RE: PF-24-00003 WSDOT Weigh Station

Project Name: WSDOT Weigh Station

Case Number: PF-24-00003

**TO:** All Staff  
**FROM:** Public Works Plan Review Team  
**DATE:** August 7, 2024  
**SUBJECT:** PF-24-00003 WSDOT Weigh Station

Critical Areas Map

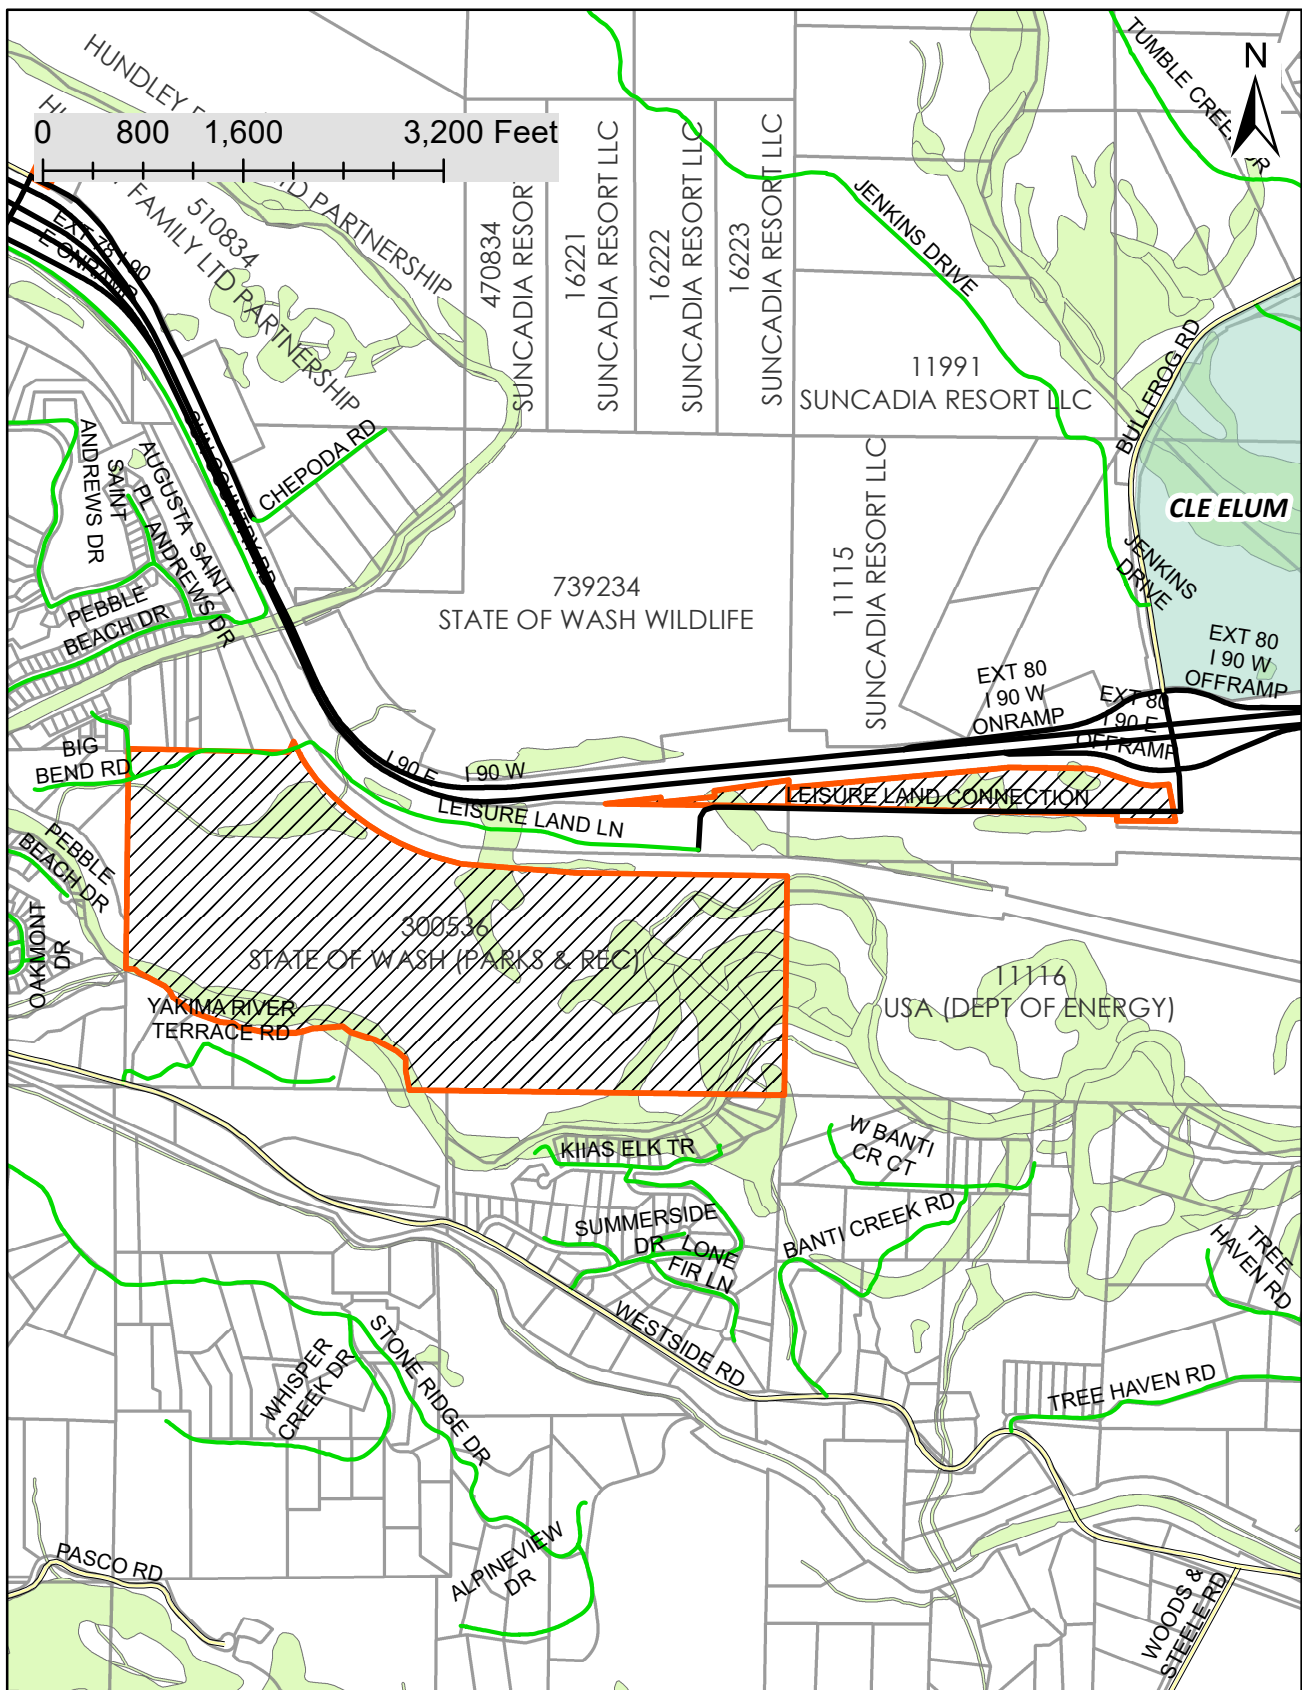
The permanent encroachment into the identified wetland buffers and removal of the forested habitats on site will have an impact to wildlife and habitats in the area and mitigation to compensate for the loss of habitat may be appropriate, after minimization measures have been incorporated.

We recommend limiting the amount of clearing and grading to only the amount needed for the project footprint; existing habitat structures such as shrubs, logs and snags can and do provide immense wildlife benefit even in developed settings. Further, minimizing the impervious surfaces associated with the project to reduce the likelihood of changes to wetland hydrology, and/or additional native plantings around the wetlands will aide in maintaining existing habitat.
